Tracy Bellamy - Epping to Thornleigh Third Track Proposal - SSI 5132

From: ben zhang <benzhang@acslink.net.au>
To: <plan_comment@planning.nsw.gov.au>
Date: 10/26/2012 2:53 PM
Subject: Epping to Thornleigh Third Track Proposal - SSI 5132
CC: <benzhang@acslink.net.au>
Attachments: Epping to Thornleigh Third Track Proposal - SSI 5132.pdf

Epping to Thornleigh Third Track Proposal. Application number SSI 5132.

Figure 5.6 Cross-section and elevation - New Cheltenham Station concourse building
Note: Indicatively added to future design

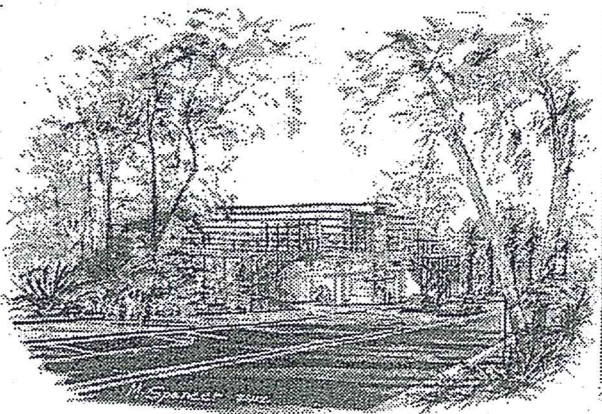
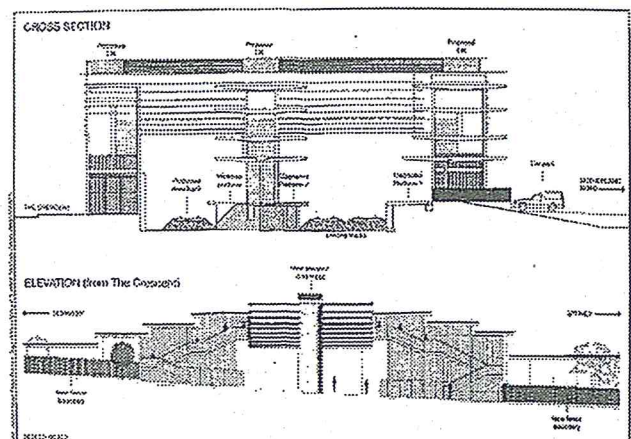
- The proposed redevelopment of Cheltenham Station shows no regard for the HCA. The visual impact of the proposed 13m high glass and steel concourse is totally unacceptable in this HCA.
